Recommendation Report for Planning Permission for Works or Extension to a Dwelling

REF NO: BE/9/21/HH

LOCATION: 11 Bedford Avenue
Bognor Regis
PO21 5AW

PROPOSAL: Single storey rear extension

Scale 1: 50 December 2020 41/21/06

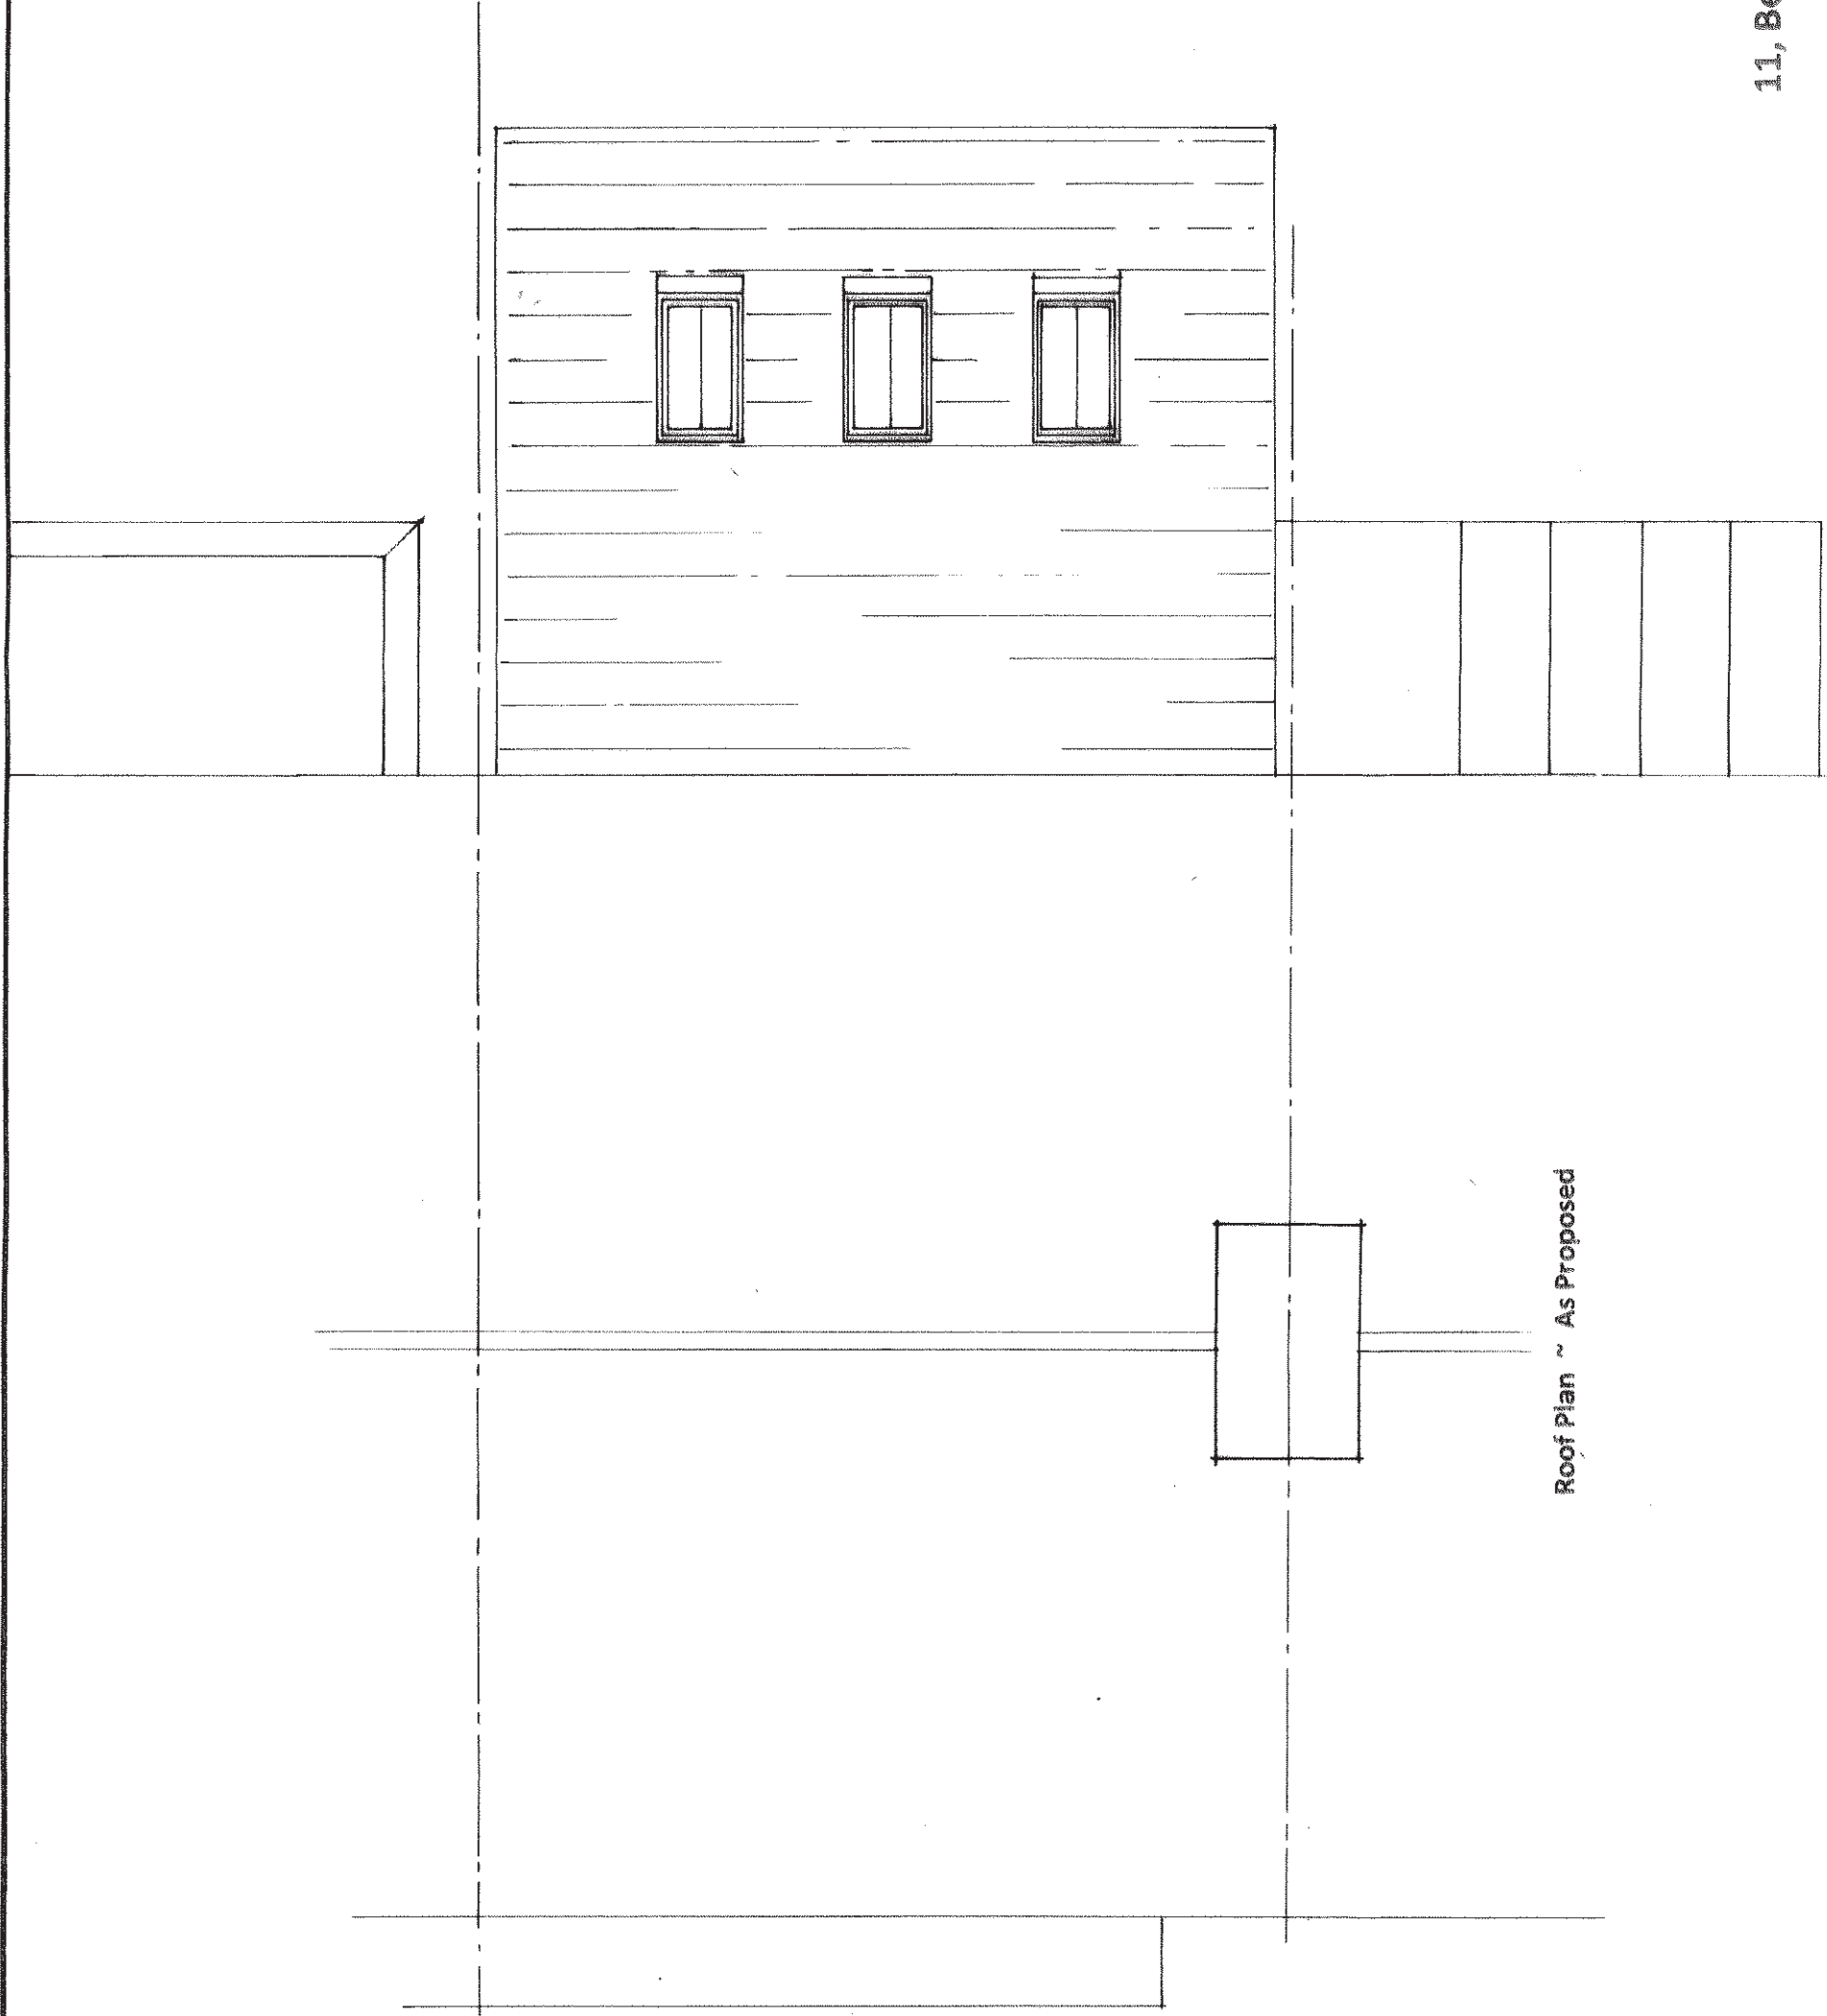
It is proposed to construct a rear mono-pitched roof extension across the width of the host dwelling. The mono pitched roof has been designed to slope away from the back of the house with small flat roof sections to accommodate the existing windows at first floor.

Scale 1:50 December 2020 41/21/05

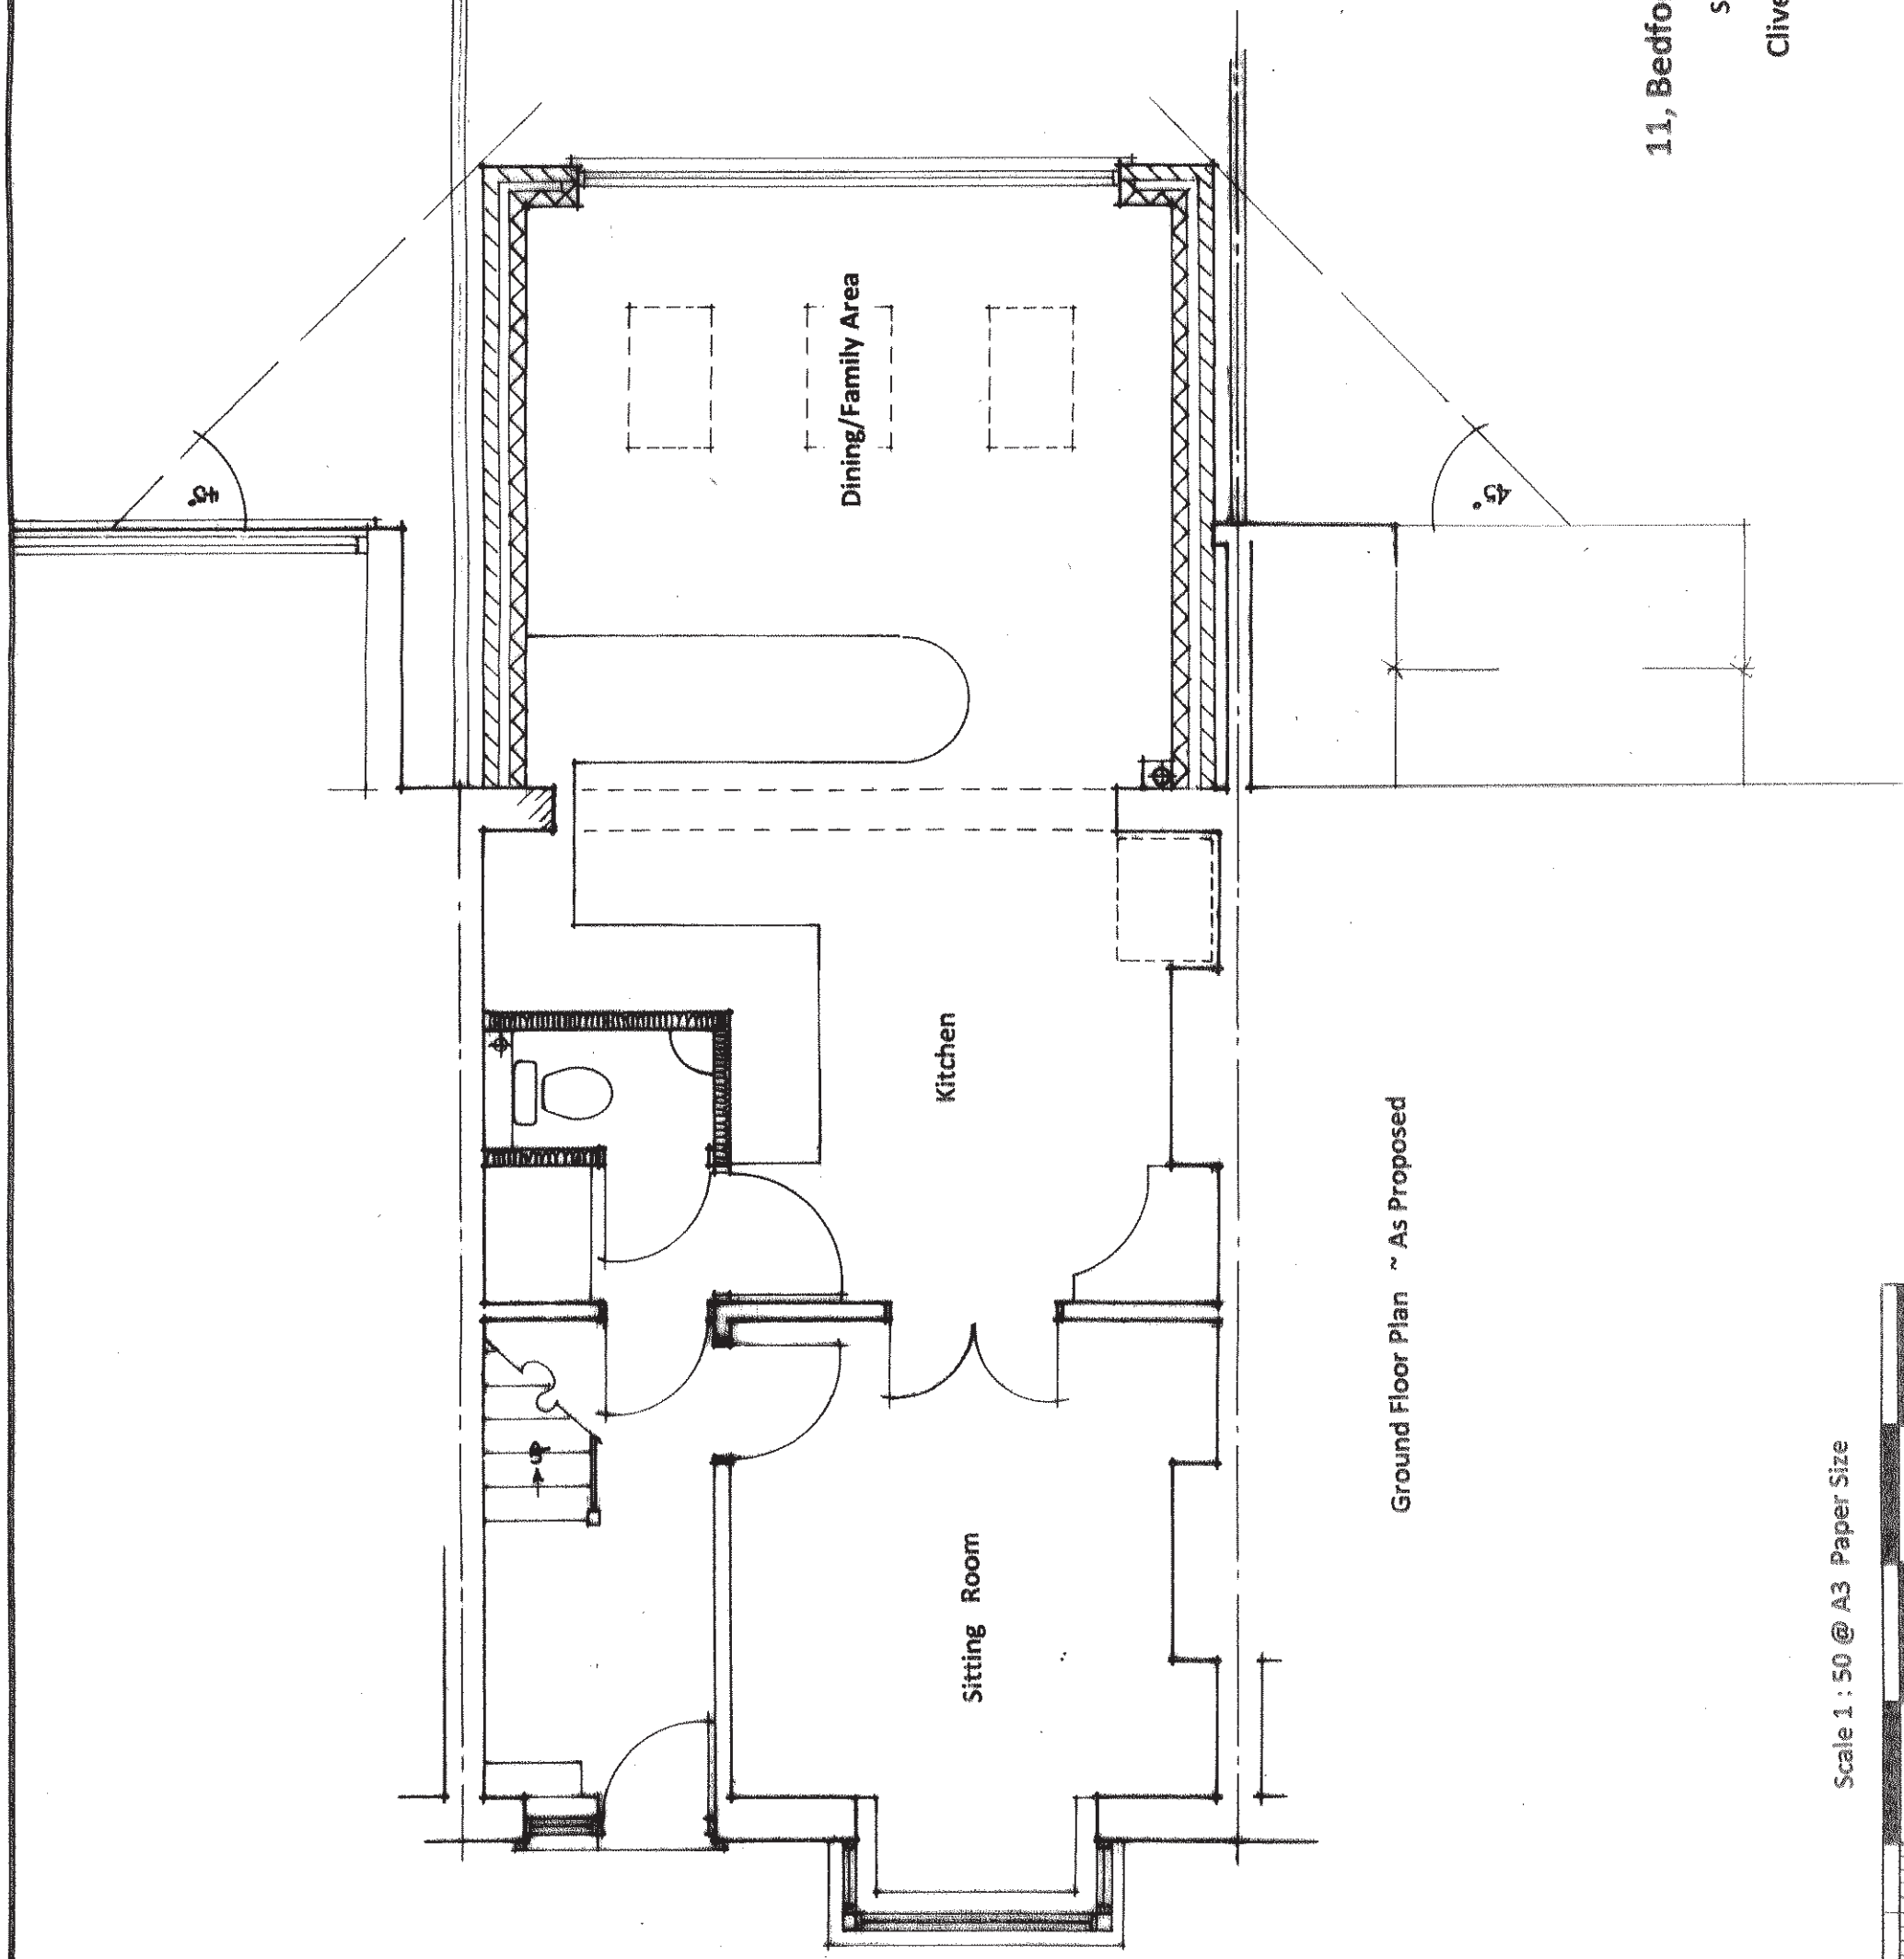
The extension does exceed the limits of the Design Guidance in terms of length by approximately 1.5m, however it has been noted that the property could extend up the 3m point without an application and anything over that but below 6m would be subject to a larger homes extension application; as of yet there have been no objections from neighbouring properties. The roof construction appears to be quite steep and potentially does bear over the neighbouring properties to some extent however both properties either side of the application site have rear protrusions of their own lessening this effect to an acceptable standard and the extension meets the requirements of the '45 degree rule' adopted in 2009 and is

Scale 1:50 December 2020 41/21/07

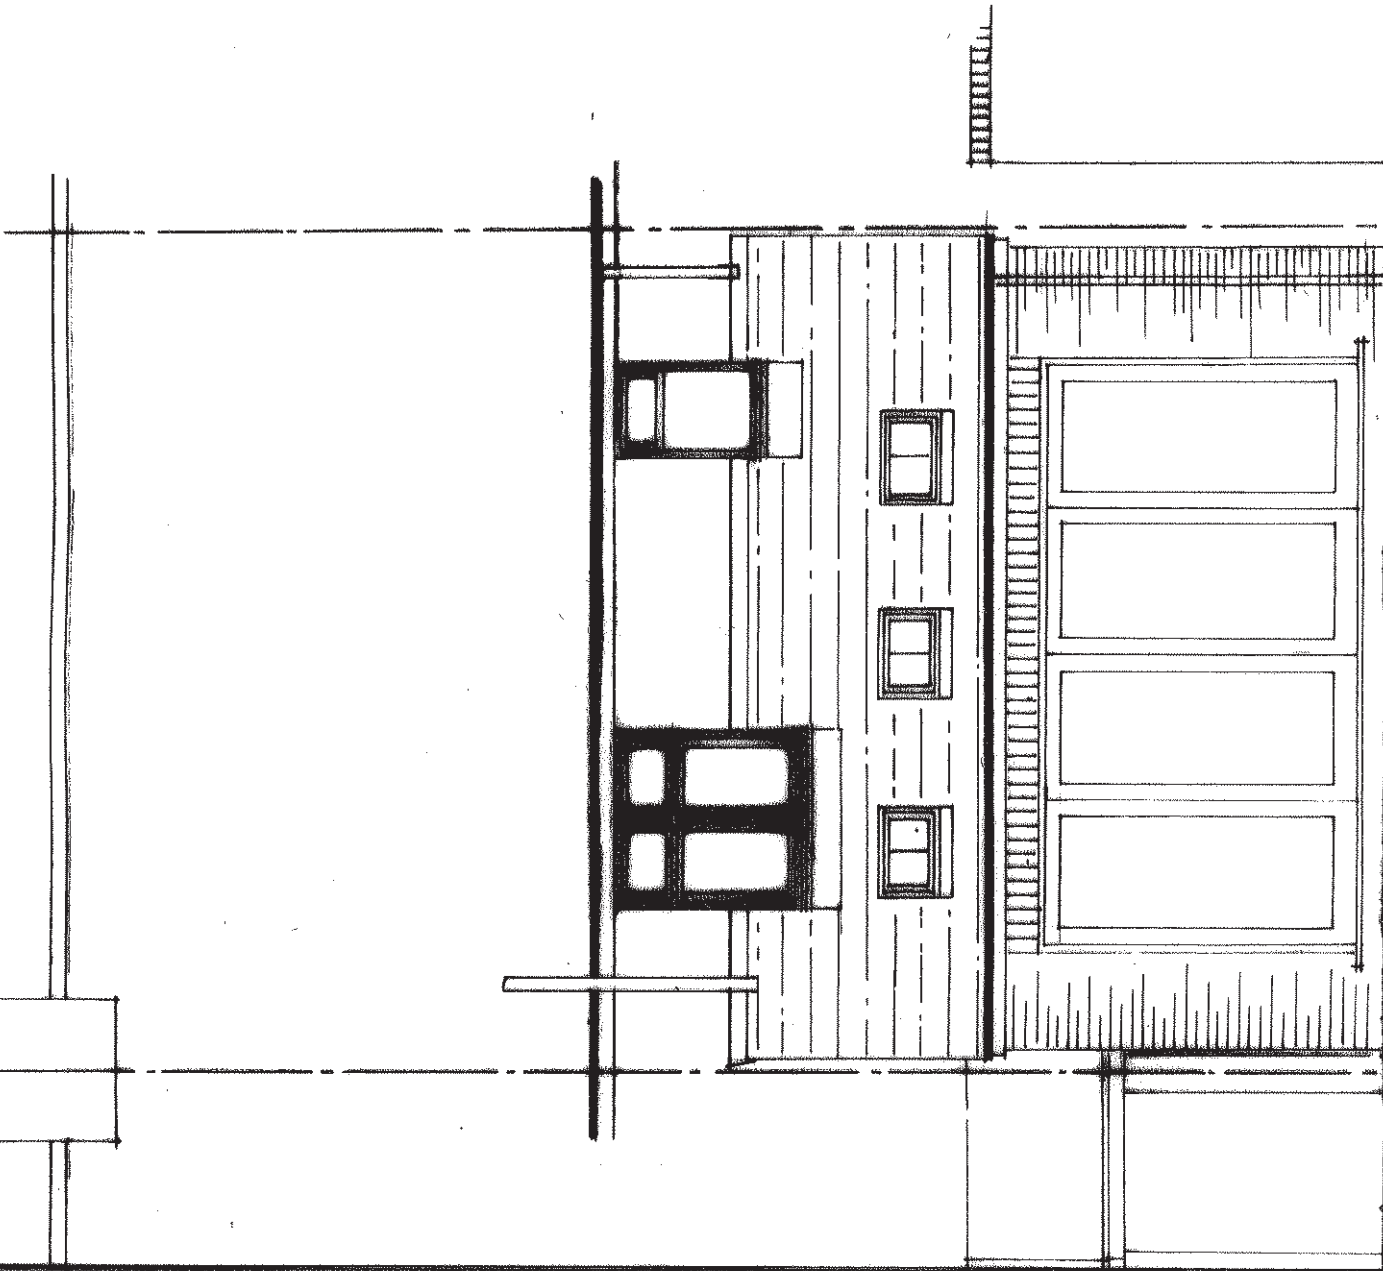
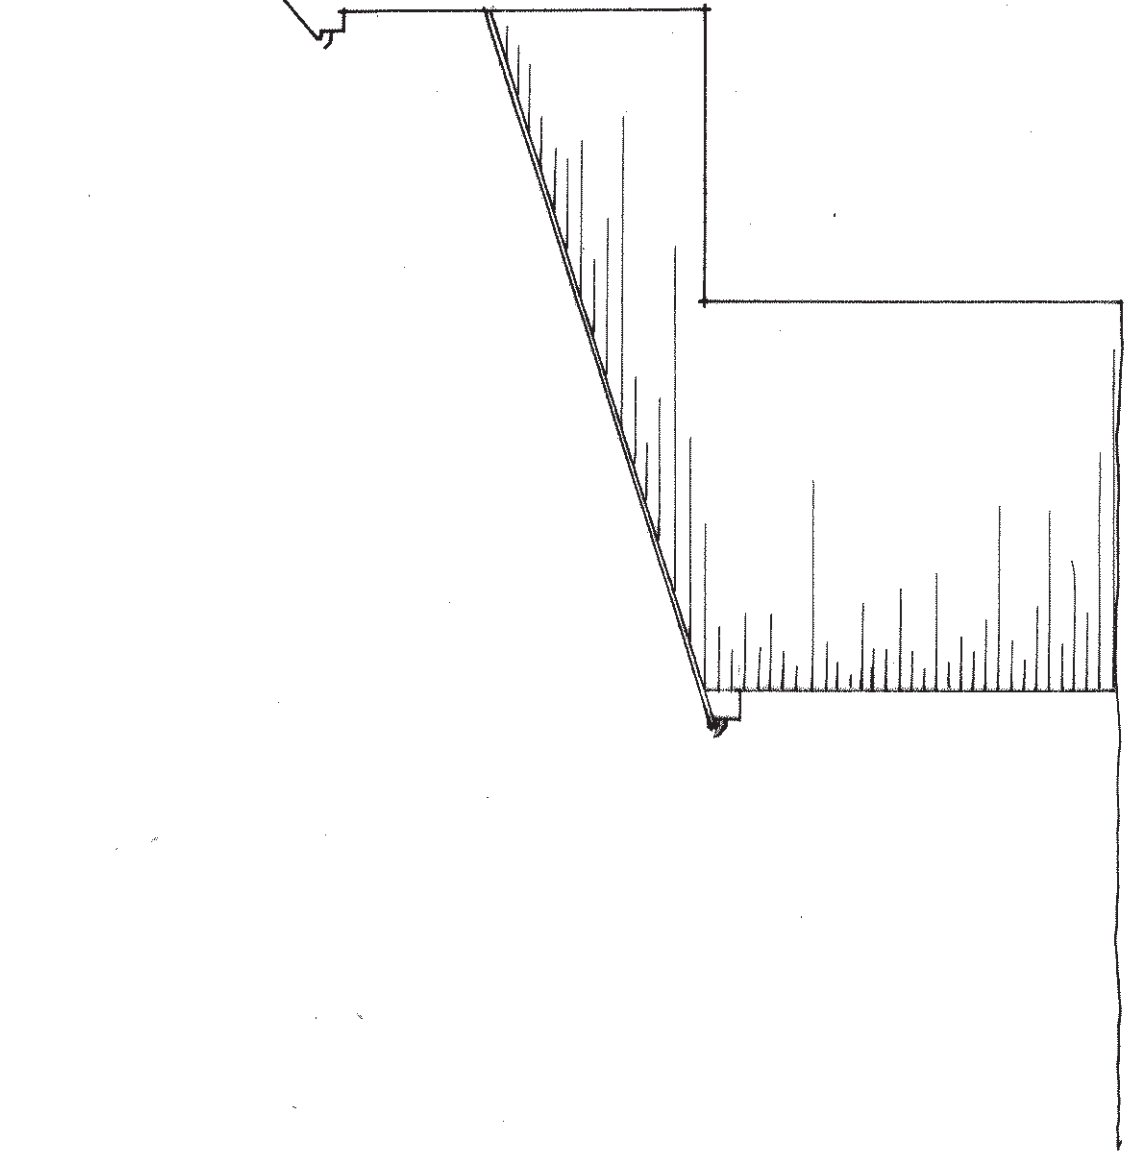
The extension appears to have been sympathetically designed to be constructed from materials which relate well to those currently in use on the host dwelling. Additionally, having regard to scale the extension, the existing eaves height is below that of the two storey dwelling. The scale of the room to be provided is thought to be appropriate for its intended use. The proposed fenestration is thought to be of a suitable scale and designed to be in keeping with the host dwelling.

The extension will not be visible from Bedford Avenue however it would be glimpsed over the rear fences from Haverfordwest Close. Its visibility from this vantage point is not seen to be detrimental to the application because of the extensions traditional design; additionally, it is noted that there are various outbuilding/garages to be found in the rear gardens of neighbouring properties, all with much more visible positions on the road side. The extension is visually attractive and integrate well with the existing dwelling therefore having regards to the design and visual amenity, the proposal is not deemed to adversely impact the location or host dwelling in accordance with DDM1 and DDM4 of the Arun Local Plan and the Arun Design Guide.

In terms of overlooking, all proposed fenestration will be located at Ground Floor level and face towards the private amenity space to the rear of the property, therefore no new views, other than those already achievable will be afforded to the proposed development.
